OXFORDSHIRE COUNTY COUNCIL'S RESPONSE TO CONSULTATION ON THE FOLLOWING DEVELOPMENT PROPOSAL

Application no: 22/00747/OUT

Proposal: Outline planning application for the development of up to 370 homes, public open space (including play areas and woodland planting), sports pitches and pavilion, drainage and engineering works, with all matters reserved (appearance, landscaping, layout and scale) except for vehicular and emergency accesses to Bicester Road.

Transport Schedule

Articulated Vehicle Entry North
1:500

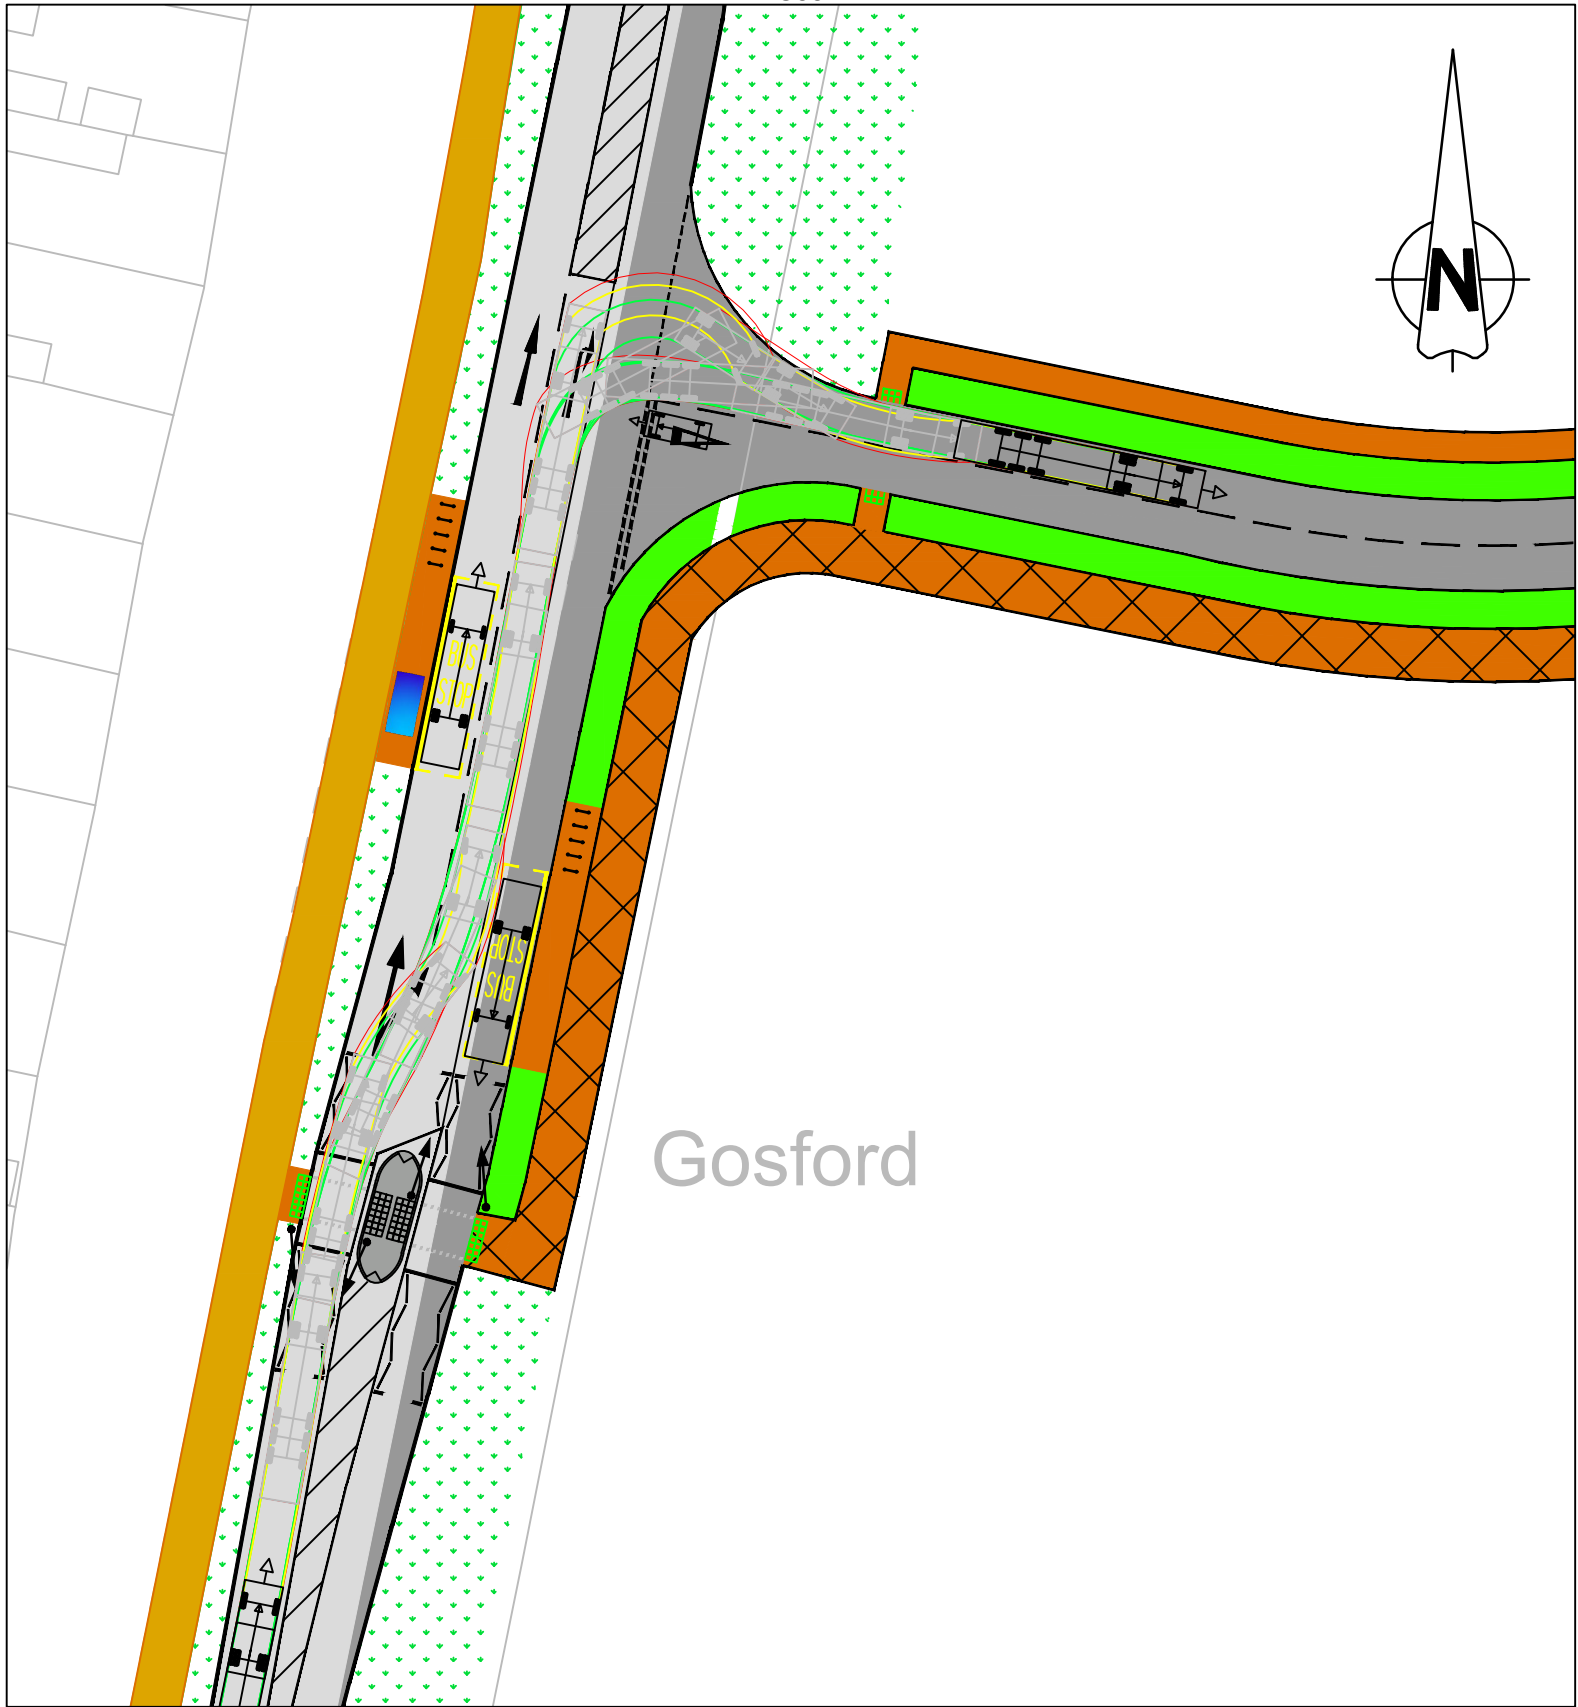
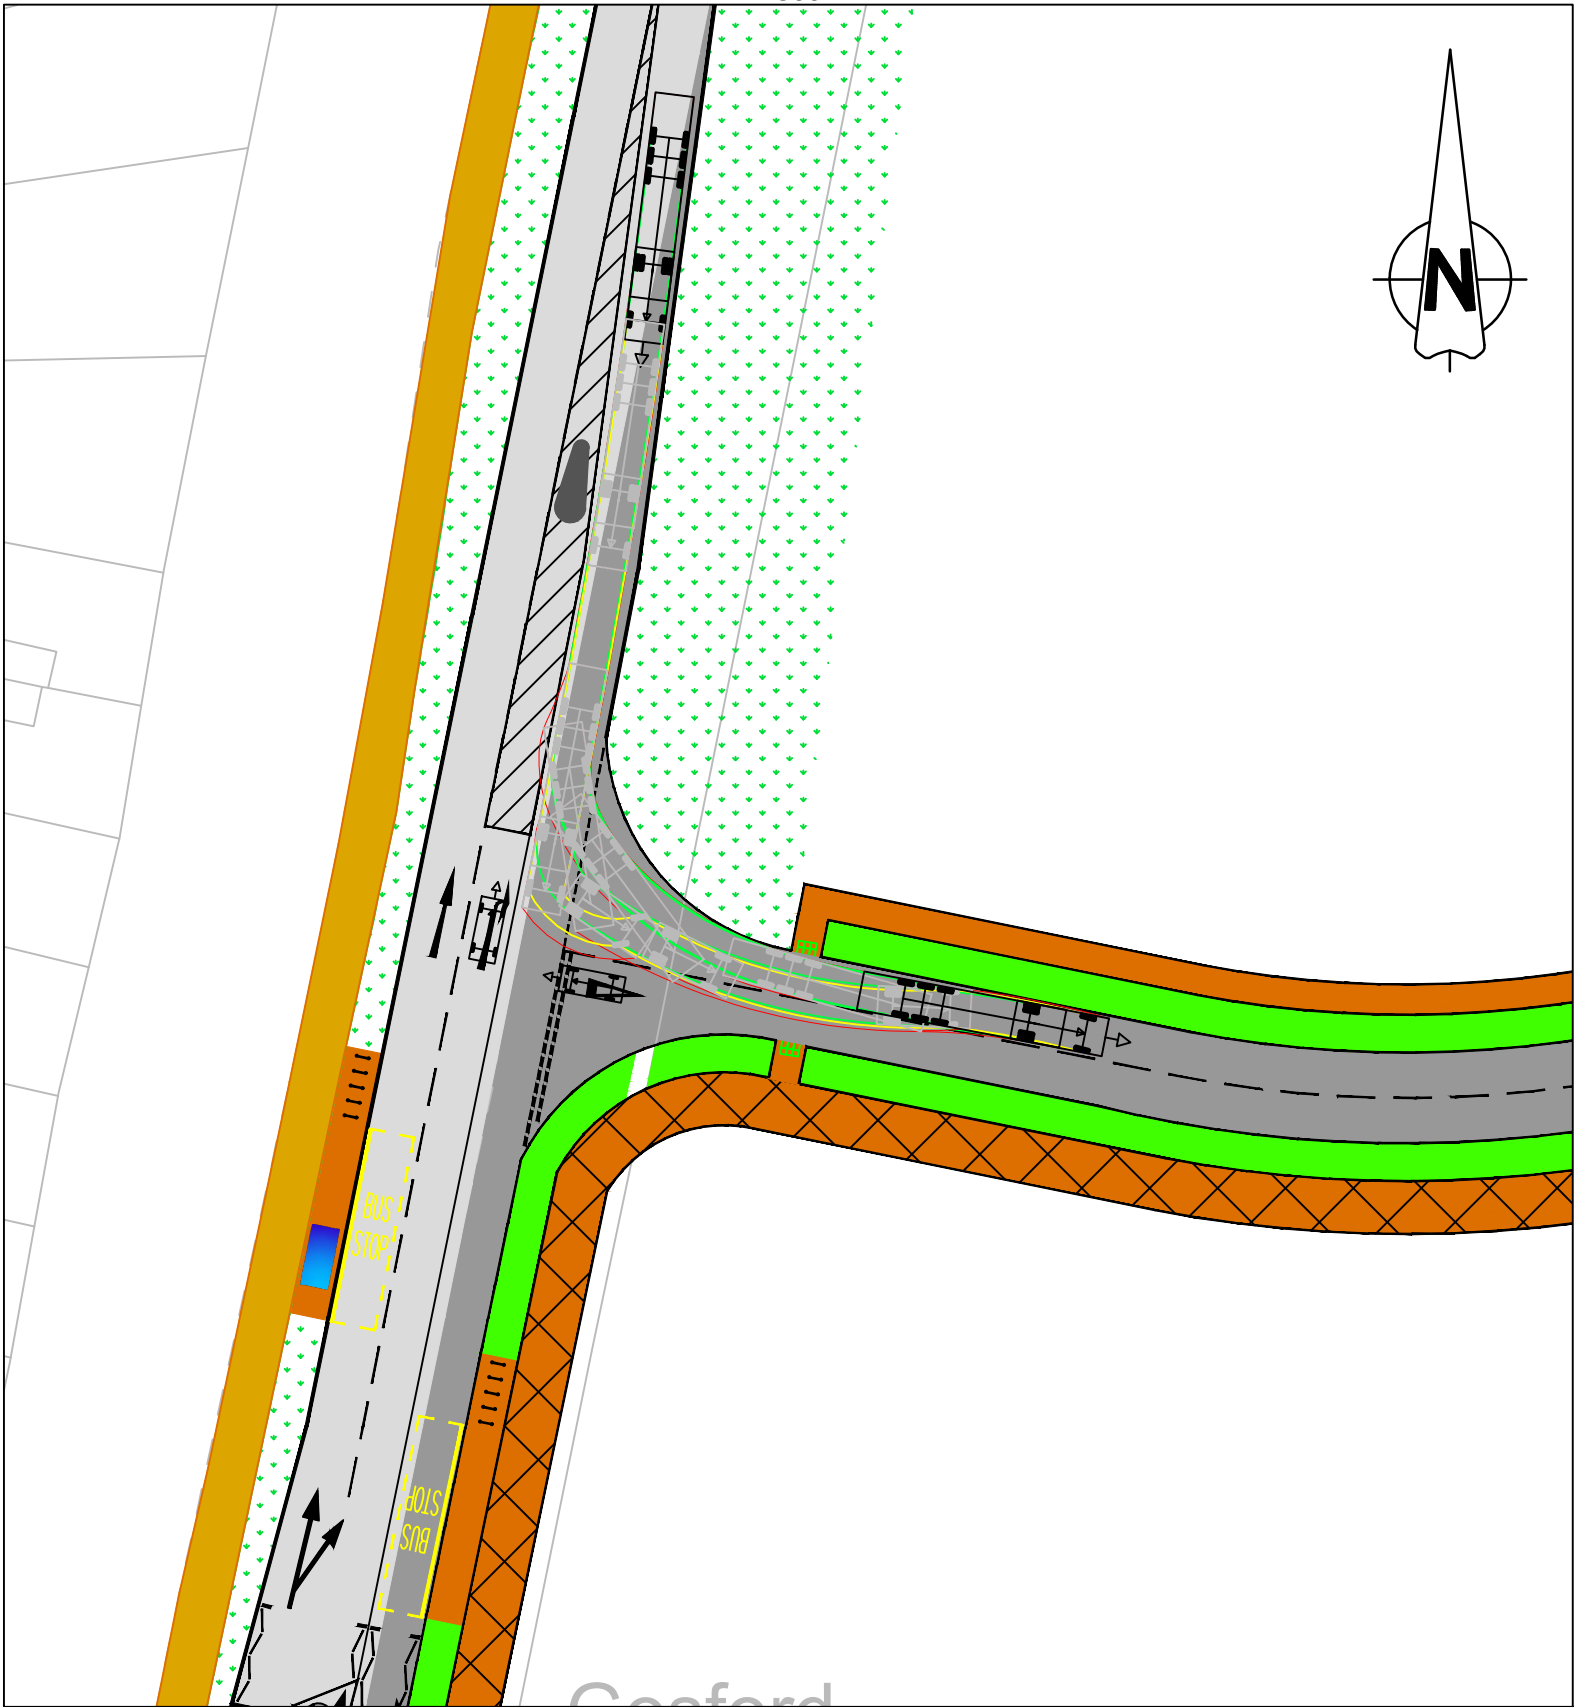
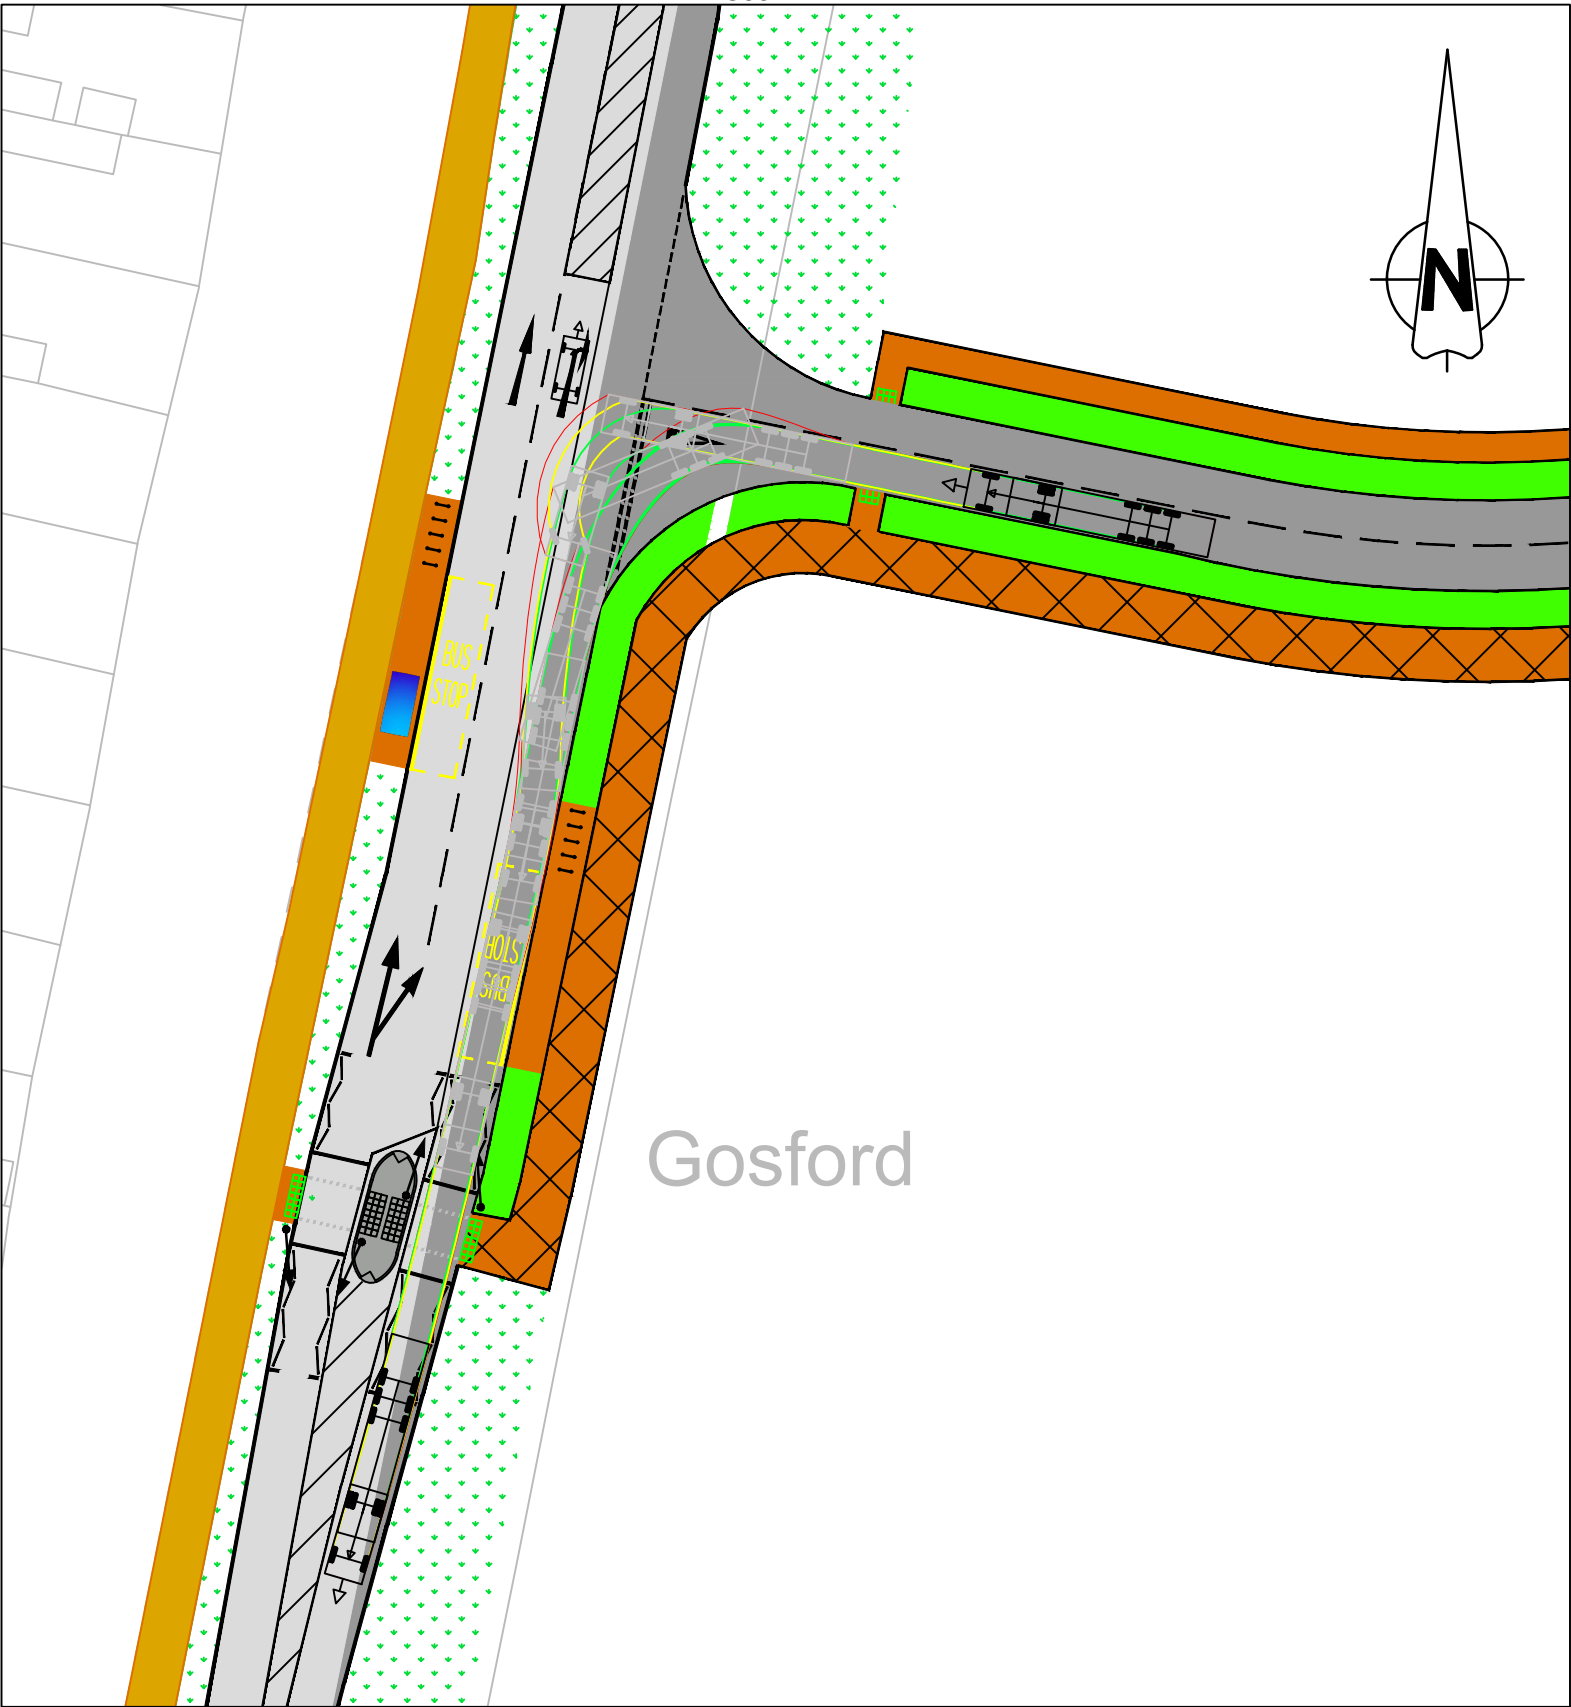
Para 3.5 acknowledges that the swept path drawing exercise was excluded in the previous submission. This has now been appended to the TN, reviewing which I note that the left-out manoeuvres cannot be safely completed in event of waiting right turning vehicles. To address this, it is suggested that the first 15m of the access need be widened to 5.5m. Alternatively, amendments to the access arrangement that take the form of a localized widening of the carriageway to ensure such vehicles can safely egress. **(Reason for objection)**
